Consultation Response from KC,
Trees

2023/92712 Land adjacent, 36 Oxford Road, Dewsbury, WF13 4LL

Erection of 40 bed care home and 12 independent supported living units (use class C2) with associated works including the formation of car park and service access

Date Responded: 22/11/2023

TYPICAL FOOTWAY BUILD-UP DETAIL

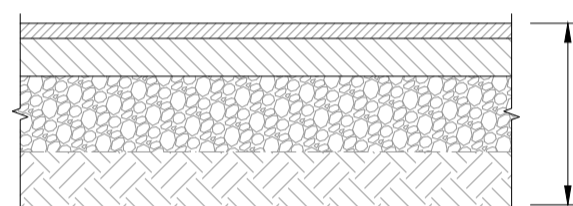
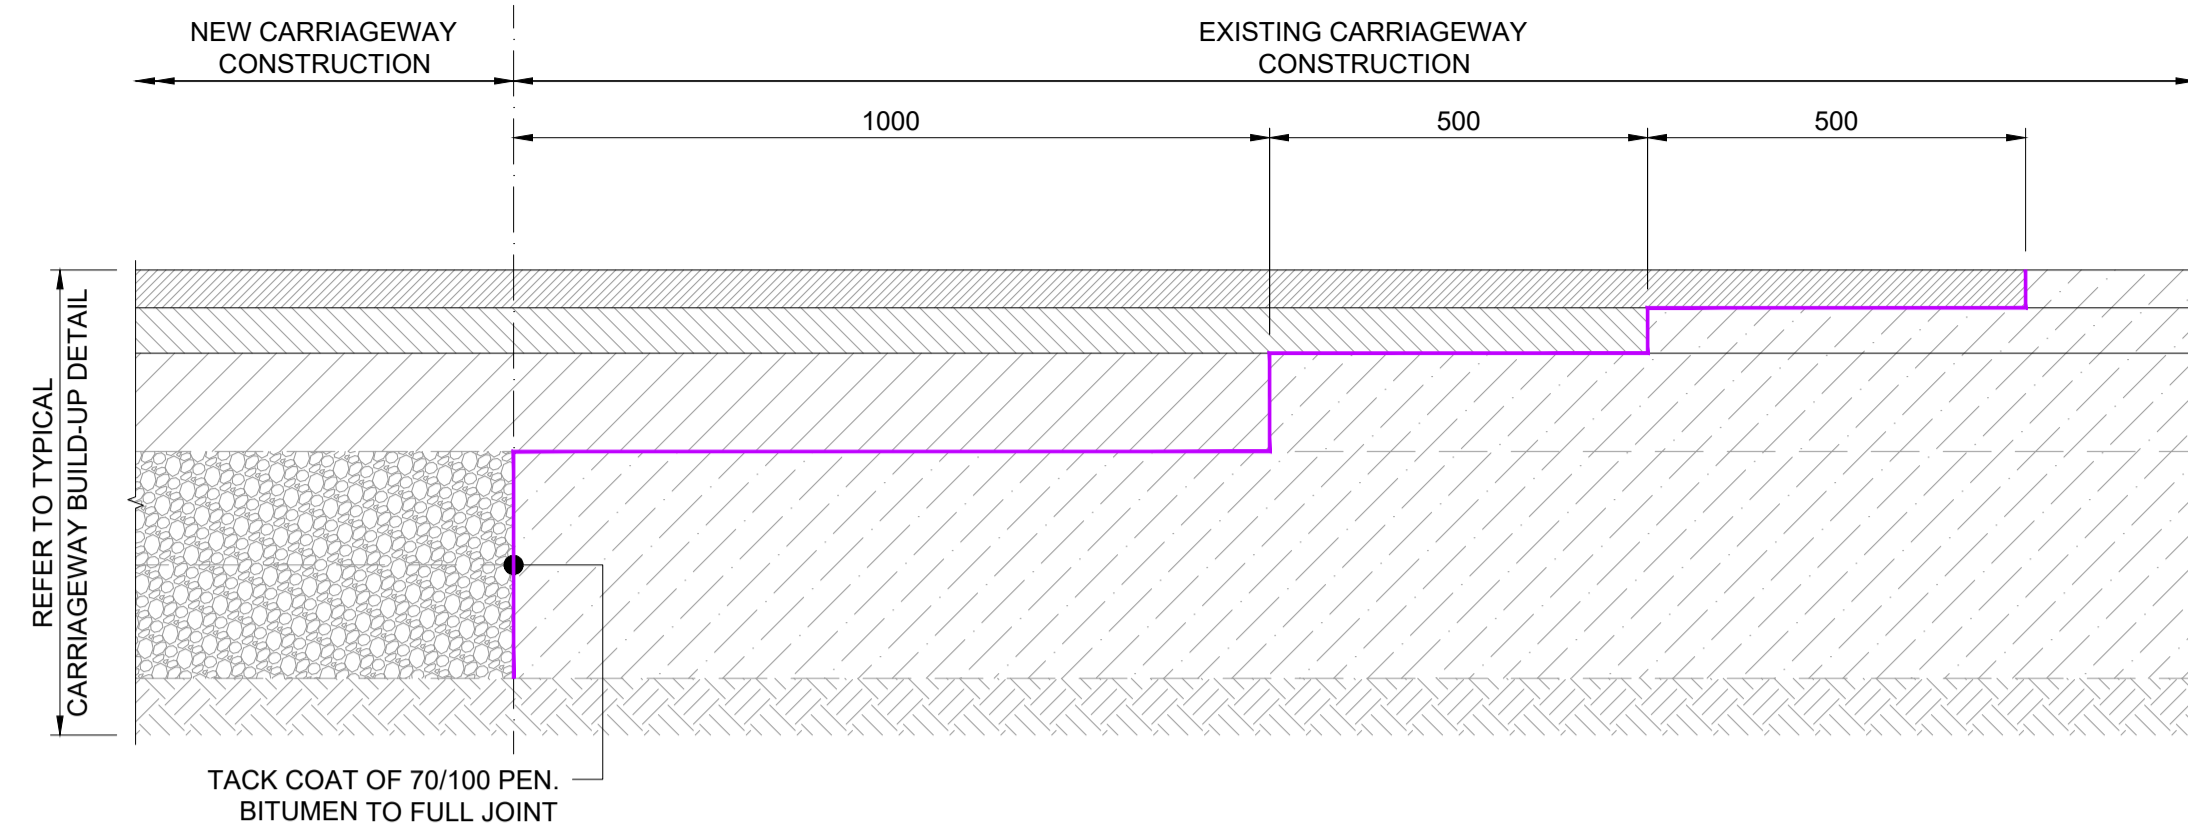
- Pile and beam foundation are preferred within footprint of western elevation of unit within the RPA of T26, T27, T28 and T29.
- Specific details on how the footpath within the RPA's of retained trees T26, T27, T28 and T29 will be construction. A geo textile "no dig" construction method is required.
